Issue Specific Hearing 1

Wednesday 30 November 2022

Supplementary Agenda

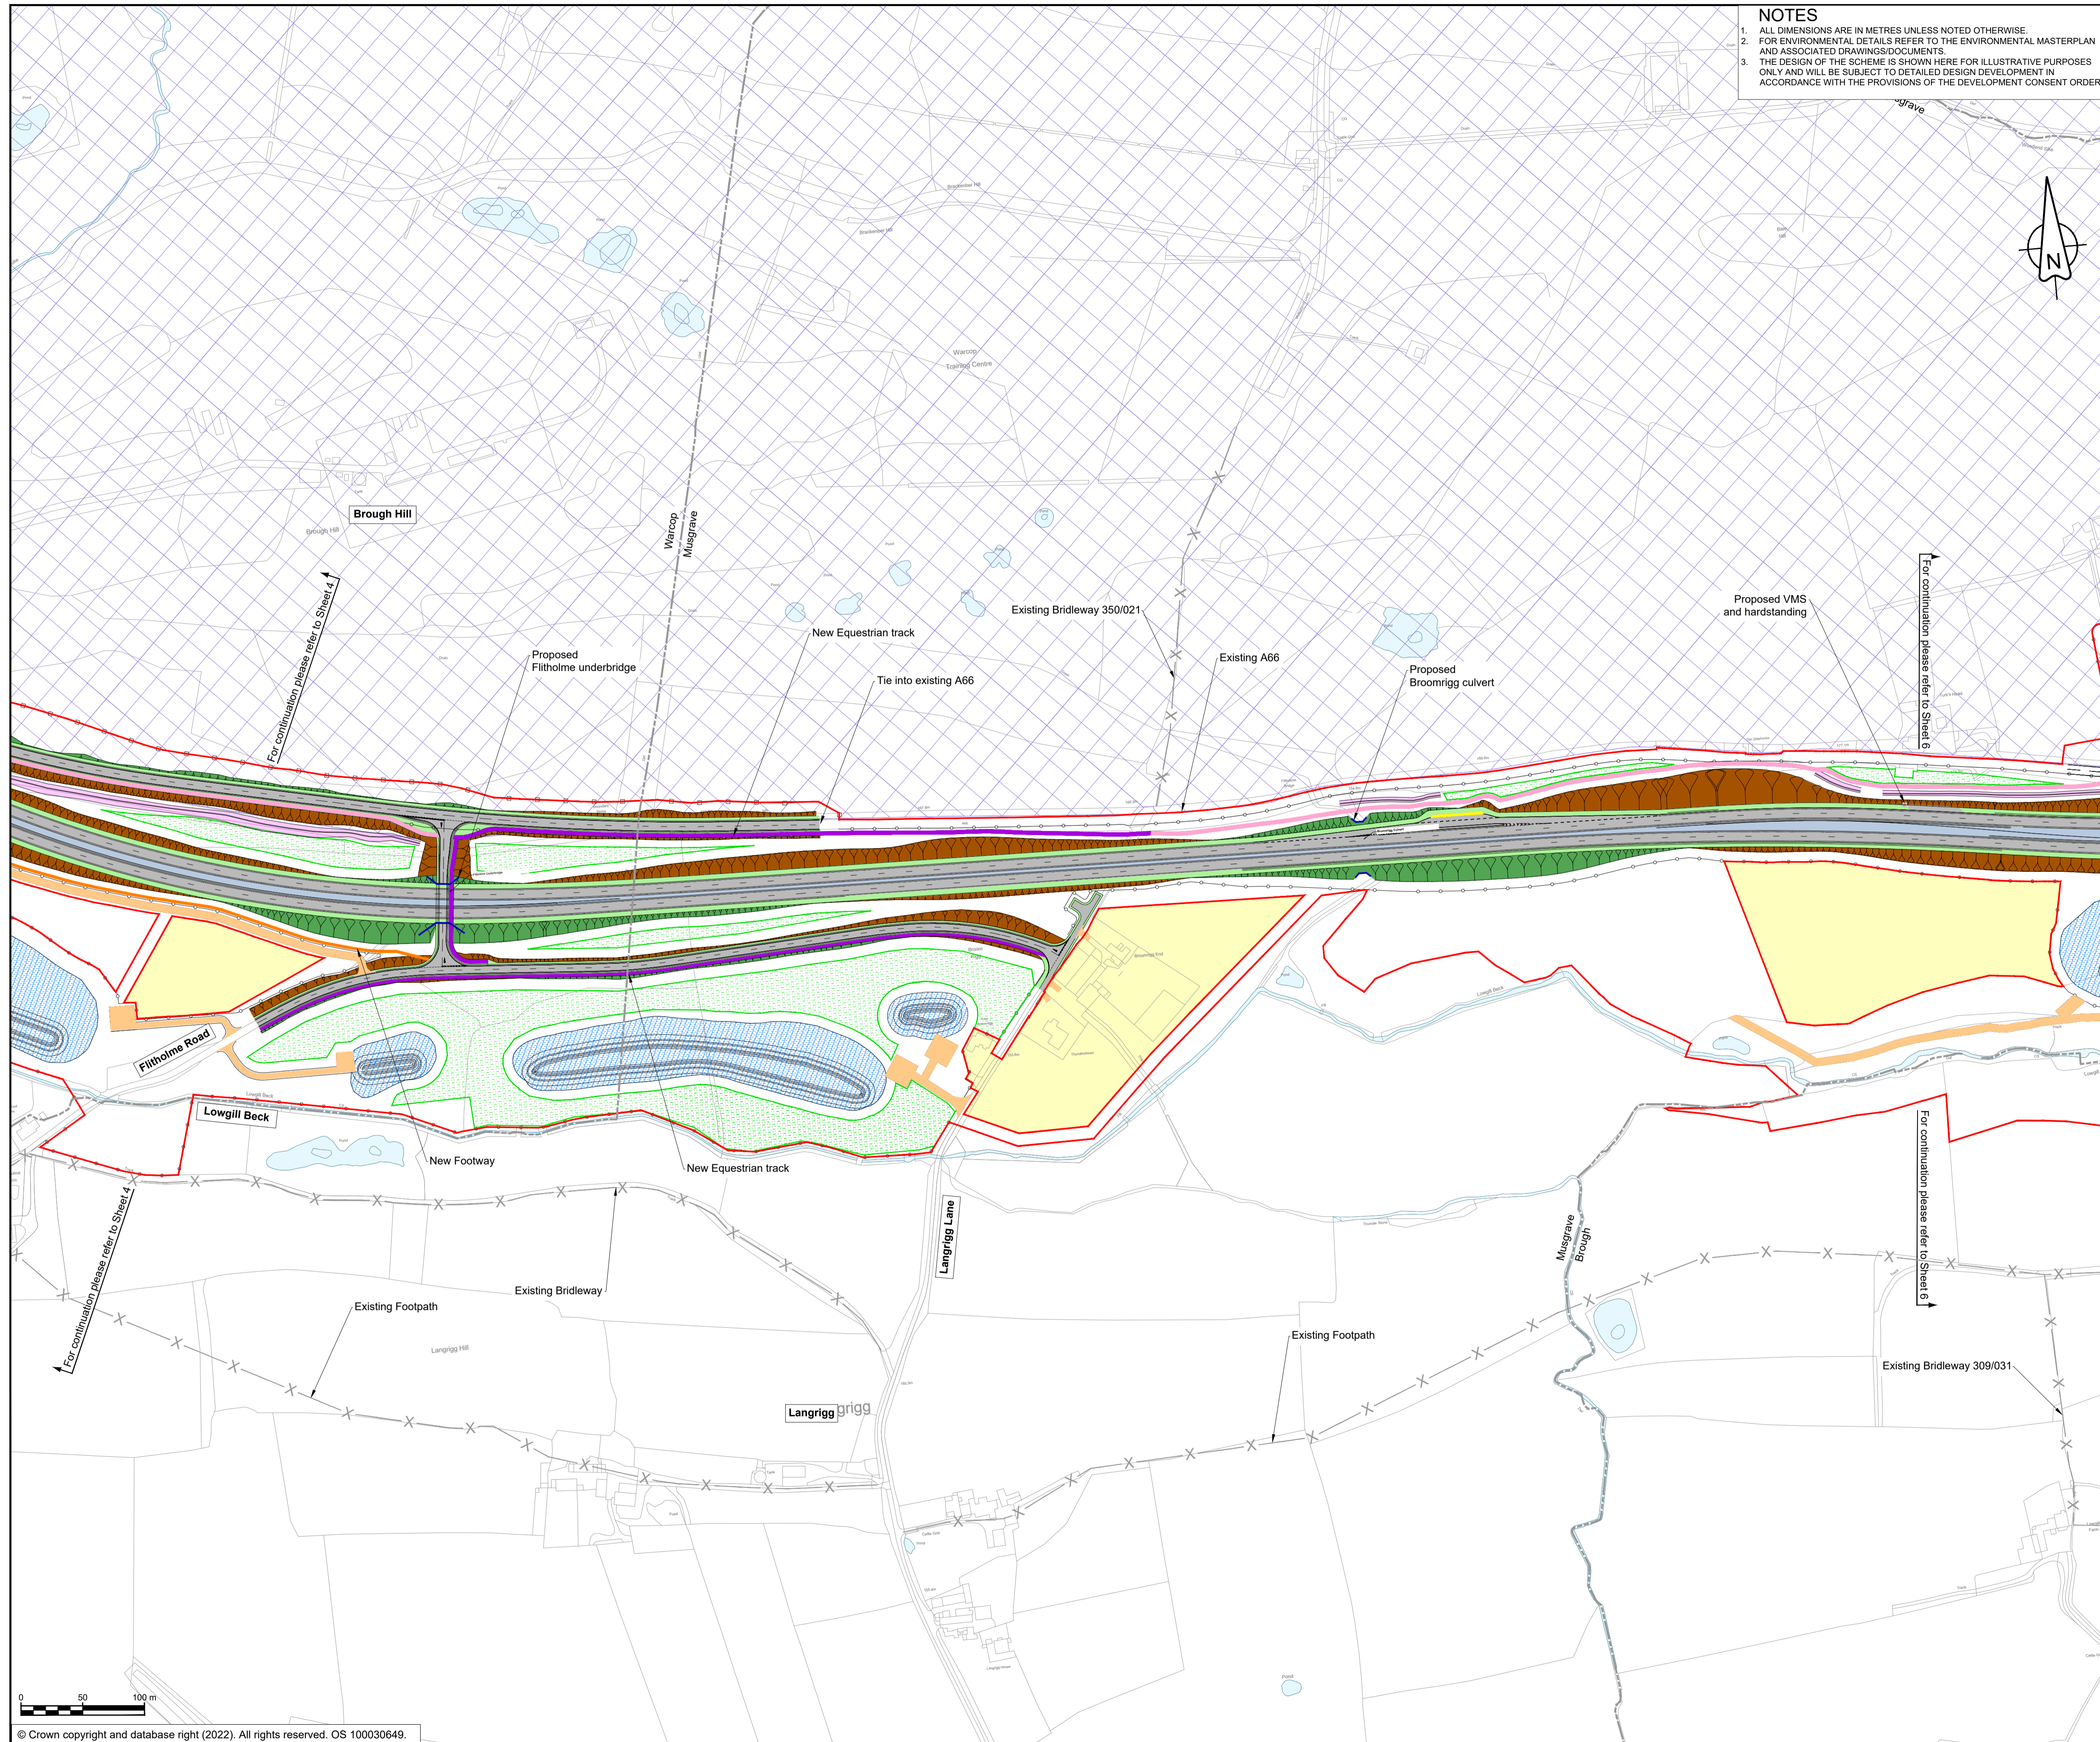
The ExA wishes to examine the design arrangement at Langrigg and concerns regarding the effect of the proposed development on the living conditions of the properties adjacent to it, one of which would be effectively encircled by roads and drainage ponds and access. Applicant to have available sheet 5 from the General Arrangement Plans for Scheme 06 [APP-014].
